CITY OF ALBUQUERQUE

January 30, 2017

RE: **Paradise Universal Apartments**
Buglo Rd NW
Grading and Drainage Plan
Engineers Stamp Date 1/26/17 (B11D010)

ENGINEER'S SEAL  3/15/17 DAVID SOULE P.E. #14522	PARADISE VIEW UNIVERSAL APARTMENTS GRADING AND DRAINAGE PLAN  1606 CENTRAL AVENUE SUITE 201 ALBUQUERQUE, NM 87106 (505) 872-0999	DRAWN BY WCWJ DATE 3-16-17 21641-LAYOUT-11-21-16 SHEET # 4 JOB # 21641
--	--	--

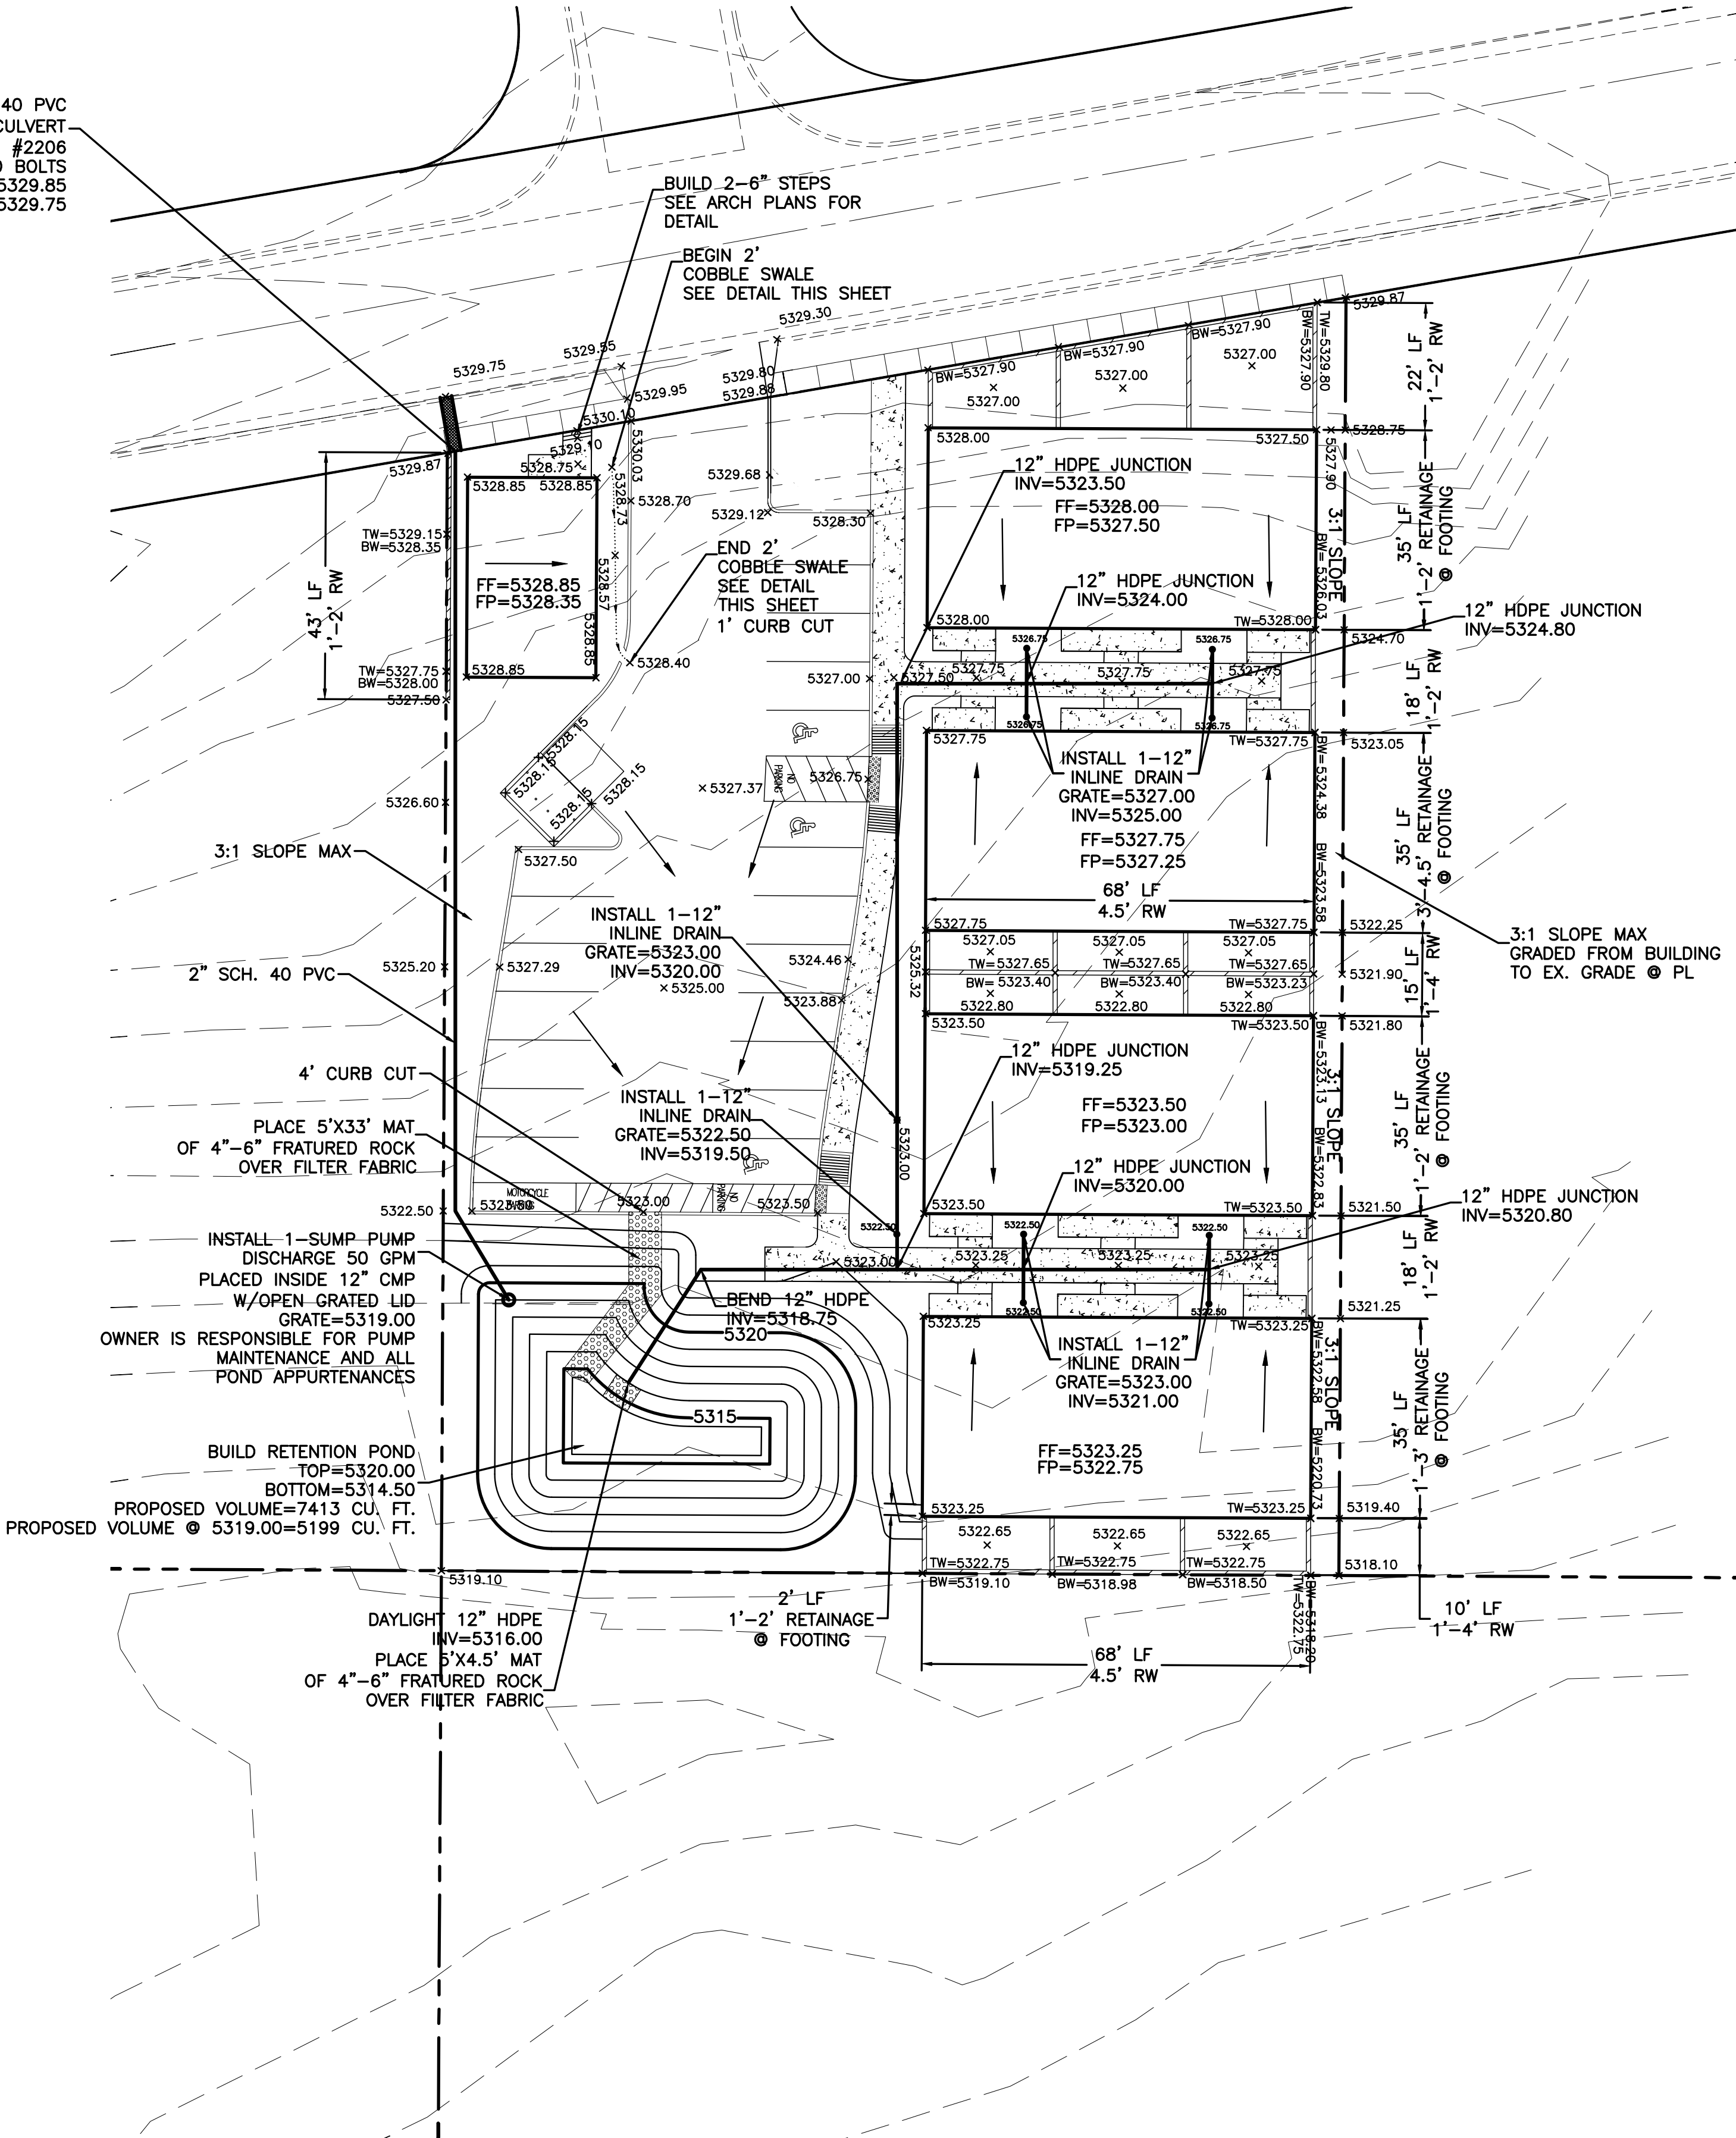
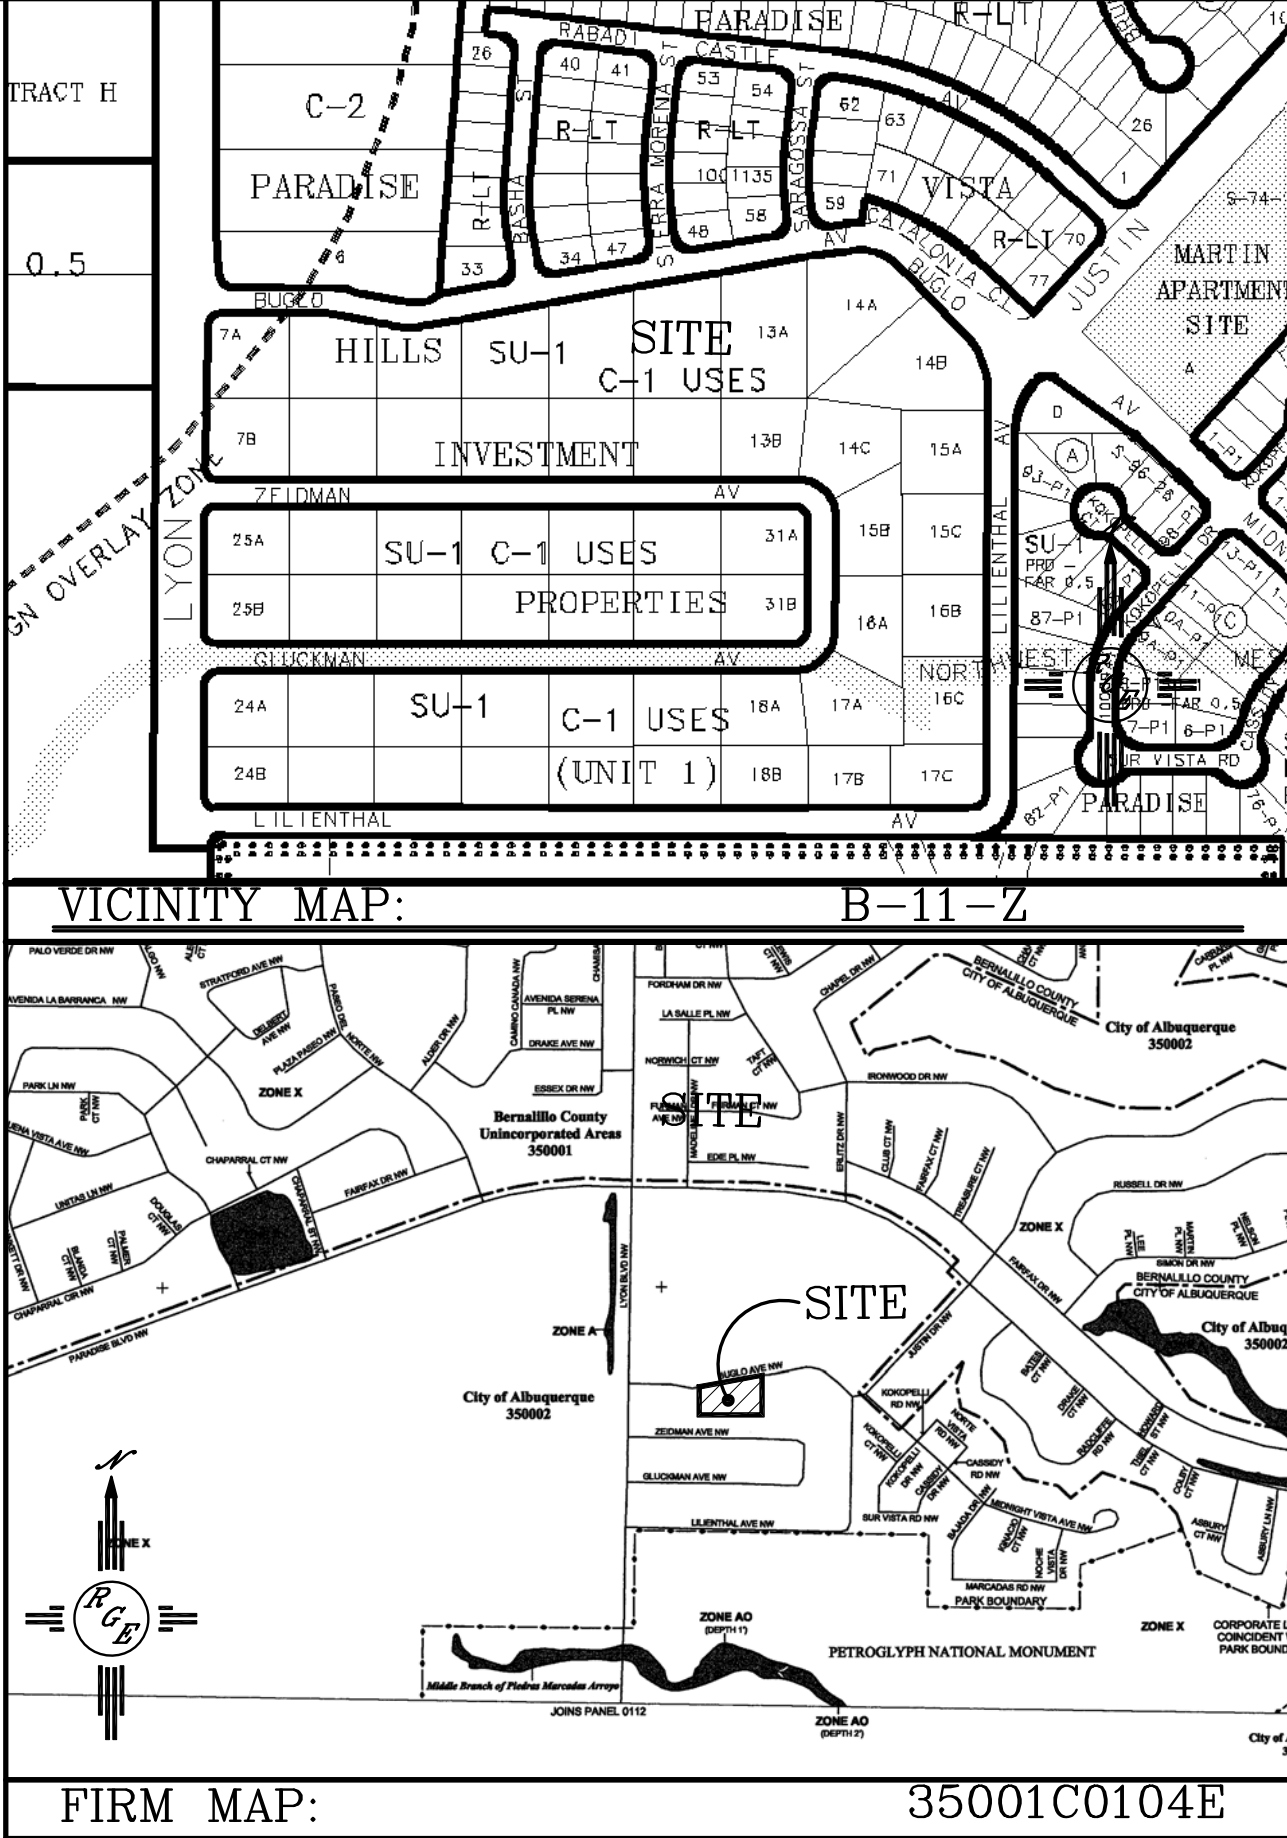
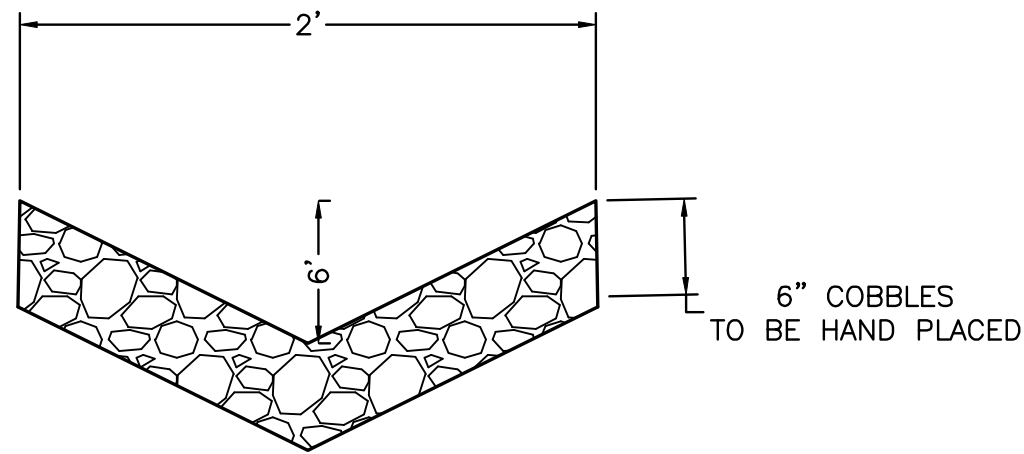
- Provide erosion protection at the pipe opening in the pond.
We have added
- Provide labels for contour lines.
We have labeled
- Recommend that a turn block 3" above grade in the garden walls is placed for emergency overflow out of rear yards.
We have added to the notes

- Provide a sketch of the retaining wall or a statement stating the retaining walls are built by others.
This is shown on note #3
- Provide a note stating the walls require a separate permit.
We have added to notes

- Provide a 1' wide sidewalk culvert extending 1' passed the property line in lieu of the 2" pipe penetration in the curb.
We have added the culvert and note

- Provide SO-19 notes for the sidewalk culvert.
We have added the so19 notes
- Provide a note stating the owner is responsible for the maintenance and up keep of the pond and sump pump.
We have added the note

- What is the 3:1 slope tie referring to?
We have added a note showing the 3:1 is slope tie from building to property line
